The Planning Inspectorate  
National Infrastructure Planning  
Temple Quay House (2 The Square)  
Temple Quay  
Bristol  
BS1 6PN

**Our ref:** NA/2018/114039/09-L01  
**Your ref:** EN010082  
**Date:** 21 September 2018

**DEADLINE 7 SUBMISSION UPDATED COMMENTS: APPLICATION BY SEMBCORP UTILITIES (UK) LIMITED FOR AN ORDER GRANTING DEVELOPMENT CONSENT FOR THE TEES CCPP PROJECT SITE OF THE FORMER TEESSIDE POWER STATION, GREYSTONE ROAD, GRANGETOWN, MIDDLESBROUGH, TS6 8JF.**

Figure 1 - Tees CCPP High Level Layout

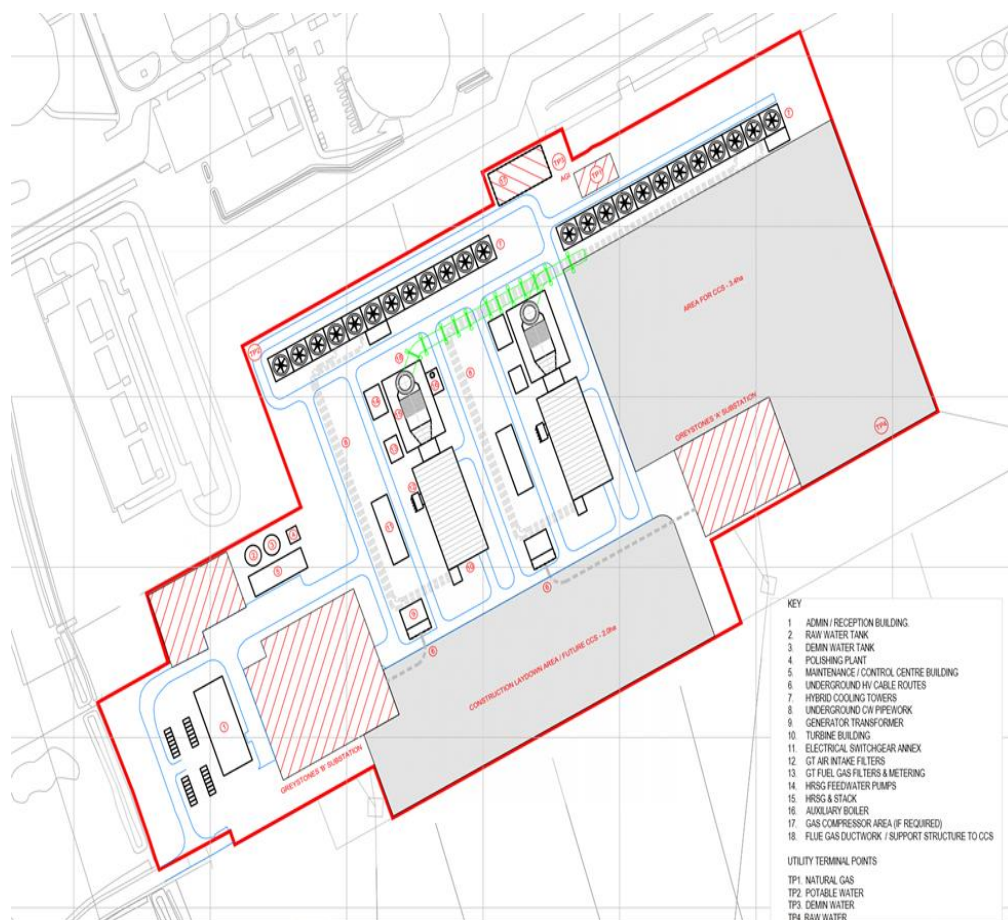
We consider that the applicant has now demonstrated that “there are no foreseeable barriers” to the technical feasibility of CCP retrofit for a 1,520MWe combined cycle gas turbine power plant (CCGT). There is sufficient space for the proposed carbon capture plant based upon the proposed 5.7Ha of land set aside for the 1,520MWe CCGT power plant and using class H gas turbines.

The applicant has, however, NOT provided sufficient information to demonstrate that it is technically feasible and that there is sufficient space to retrofit a carbon capture plant for a 1,700MWe power output. The applicant will need to provide further evidence to demonstrate the feasibility of a power plant with a maximum capacity of 1,700MWe. We, therefore, **recommend** that the DCO contains a requirement to limit the power output capacity to 1,520MWe until it can be demonstrated that a maximum capacity of 1,700MWe is feasible, as proposed by the Applicant in the AECOM memo dated 19 September 2018.

It is noted that part of the land allocated to the construction of the carbon capture plant will be outside of the Tees CCGT Order Limit. We strongly recommend that an area of land is kept available for laydown during the construction of the carbon capture plant.

We **recommend** the following amended wording for the DCO requirement. Point 2 of the requirement has been reworded to ensure that any submitted scheme to support a net electrical output of more than 1520MWe and up to 1700MWe is submitted to and approved in writing by the planning authority in consultation with the Environment Agency. We have also detailed the information that should be submitted for any scheme.

- (2) *The authorised development must not be operated at a net electrical output of more than 1520MWe and up to 1700MWe until the undertaker submits a scheme to demonstrate there is sufficient space within the order limits to comply with the land footprint requirement for the retrofitting of appropriate carbon capture storage plant and equipment for a generating station with a net electrical output of up to 1700MWe. The scheme shall be submitted to and approved in writing by the relevant planning authority in consultation with the Environment Agency. The scheme shall include:*

- *Information required by the form "Environment Agency verification of CCS Readiness New Natural Gas Combined Cycle Power Station Using Post-Combustion Solvent Scrubbing," as outlined in Annex C of the Department of Energy and Climate Change (DECC) (2009) Carbon Capture Readiness guidance, for a generating station with a net electrical output of more than 1520MWe and up to 1,700MWe.*

- *Details demonstrating how the Carbon Capture Plant will fit into the space allocated for the plant including the submission of engineering design details.*
